15 December 2016

Contact : Janine McCarthy
Our Ref: DOC2016/067269
Your Ref: SSD 7520

**State Significant Development 7520
129 Mitchell Avenue (Lots 796 and 797 DP 39877), Kurri Kurri**

GENERAL SITE LAYOUT (Drainage)

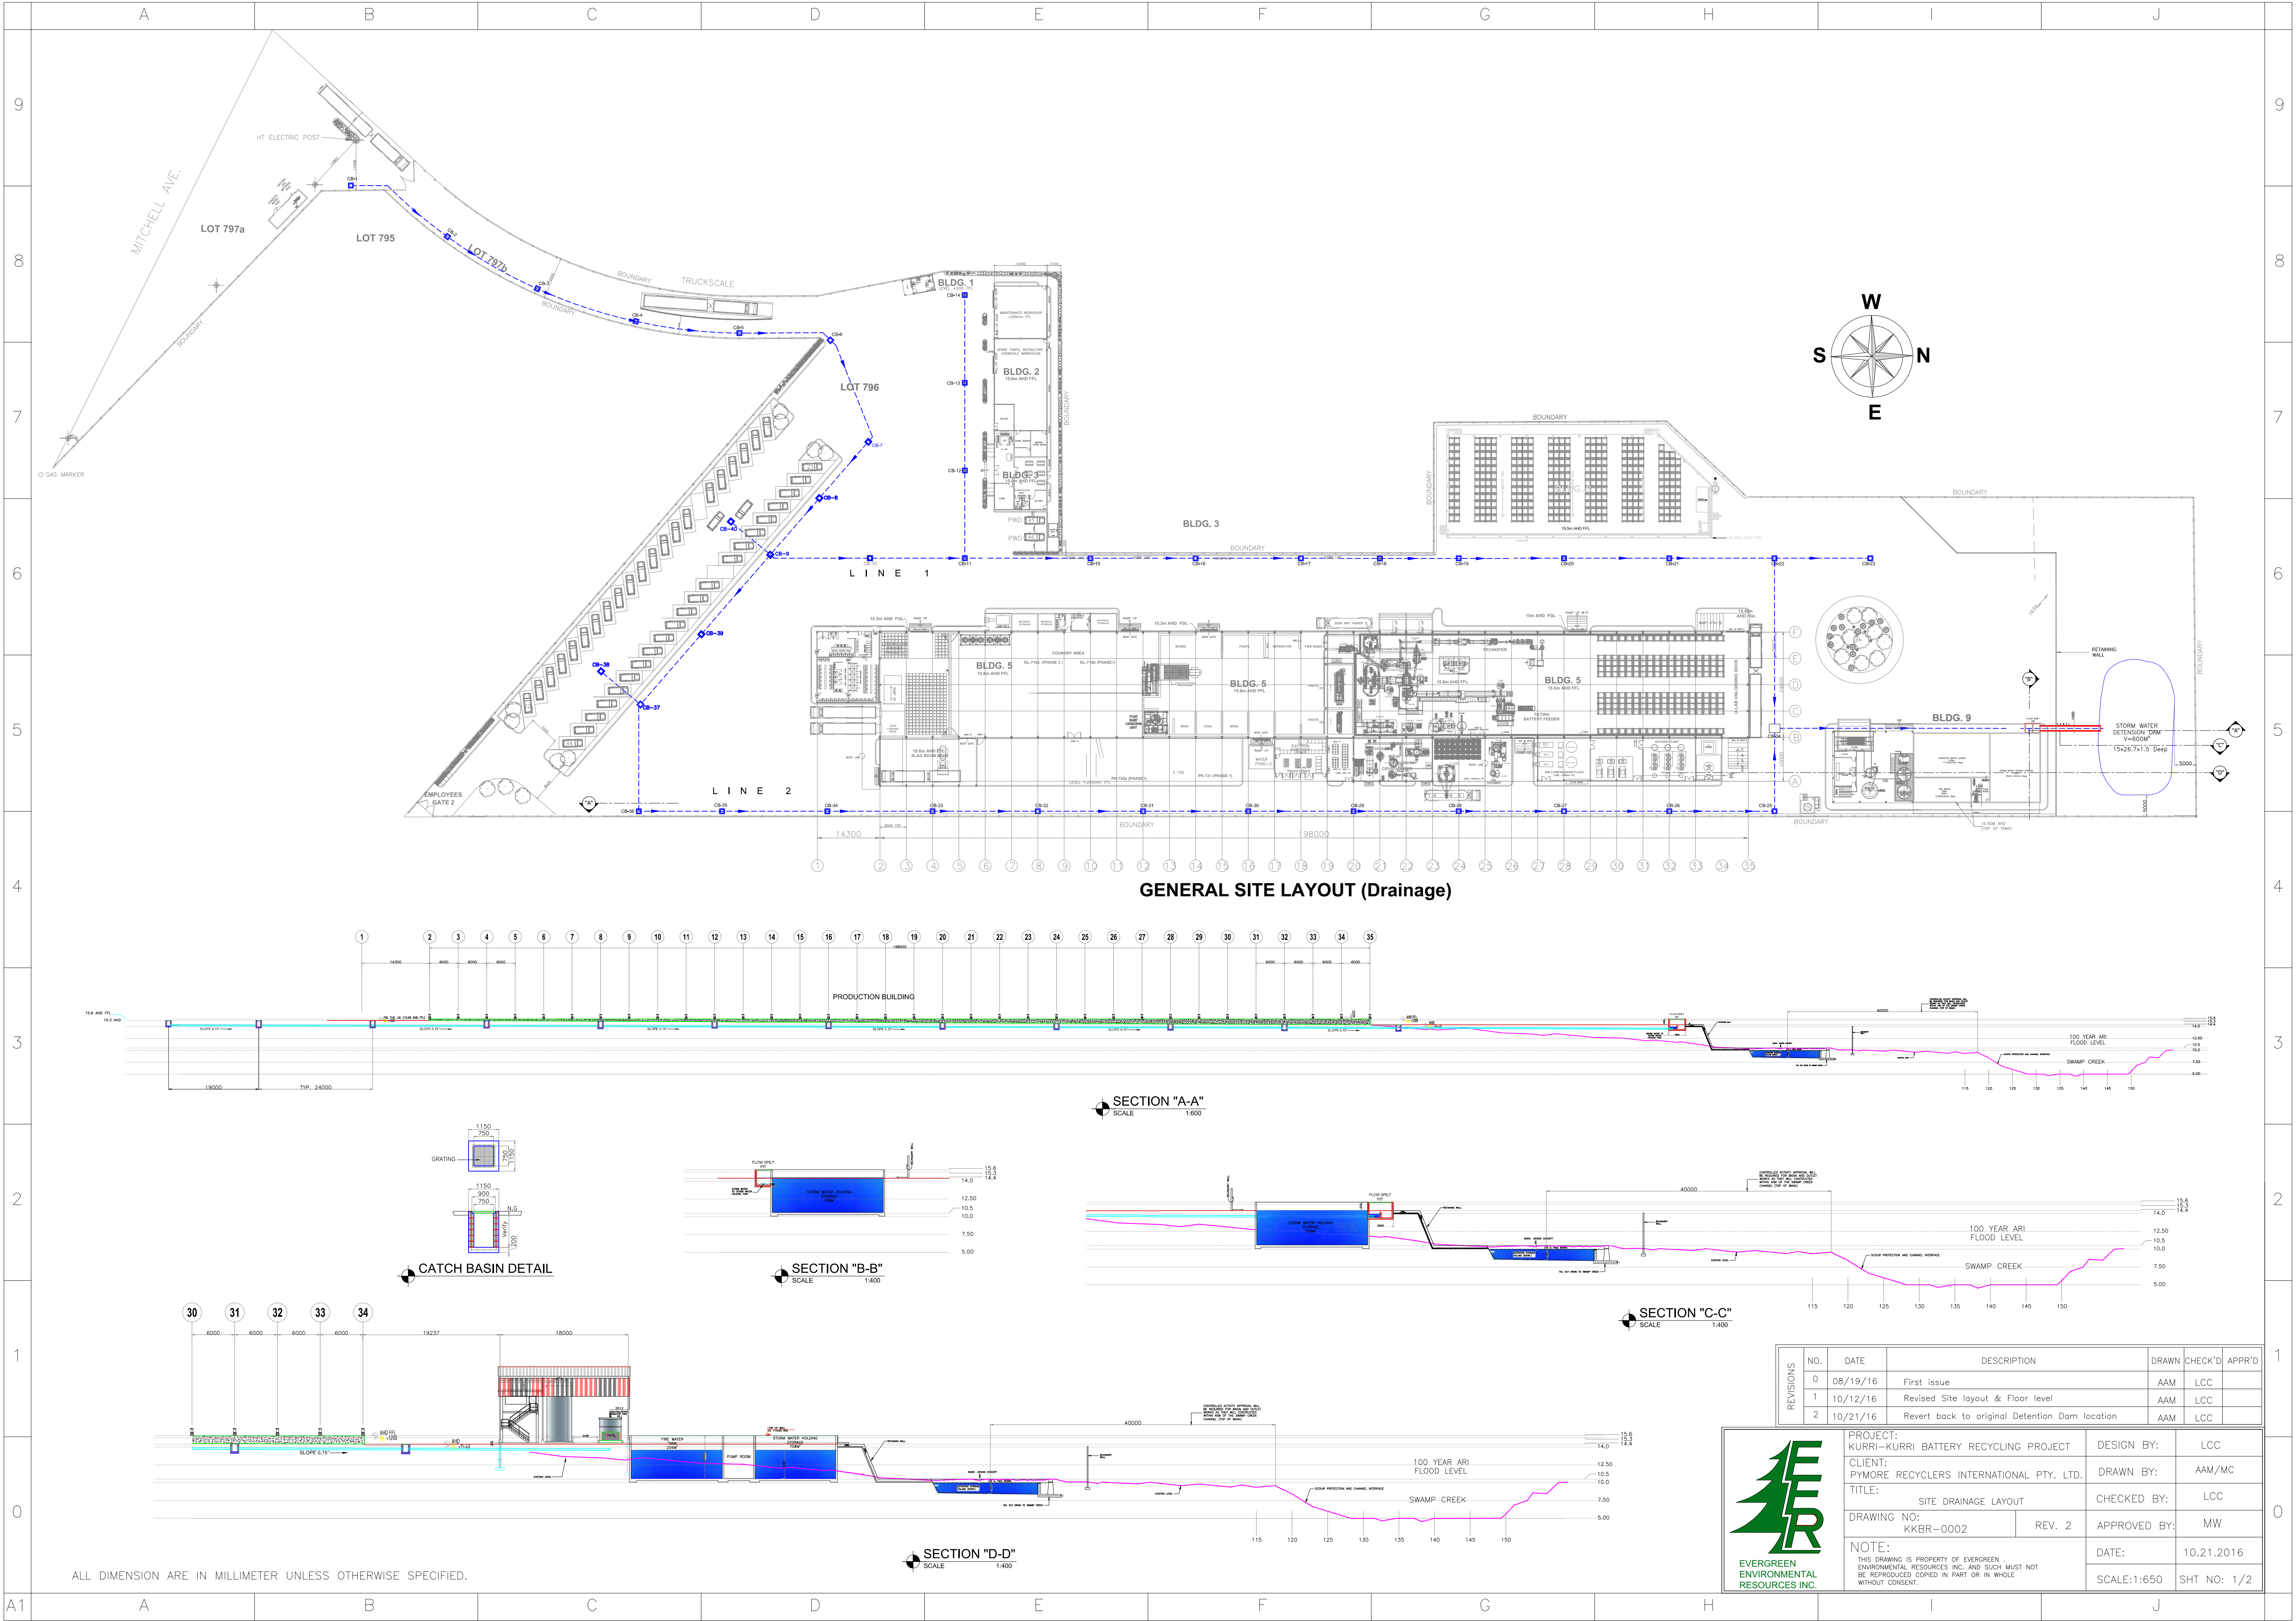
- With the proposed embankment batters being steeper than the 1V:6H, suitable basin safety measures are to be provided such as fencing around the basin.
- The onsite detention basin has been positioned below the 1% AEP flood level. As a result, the site will not adequately attenuate the pre and post developed flows for the 1% AEP and potentially the 2% AEP flood events. The basin should be relocated to be outside the 1% AEP flood plain and to ensure the outlet pipe is above the 1% AEP flood level.
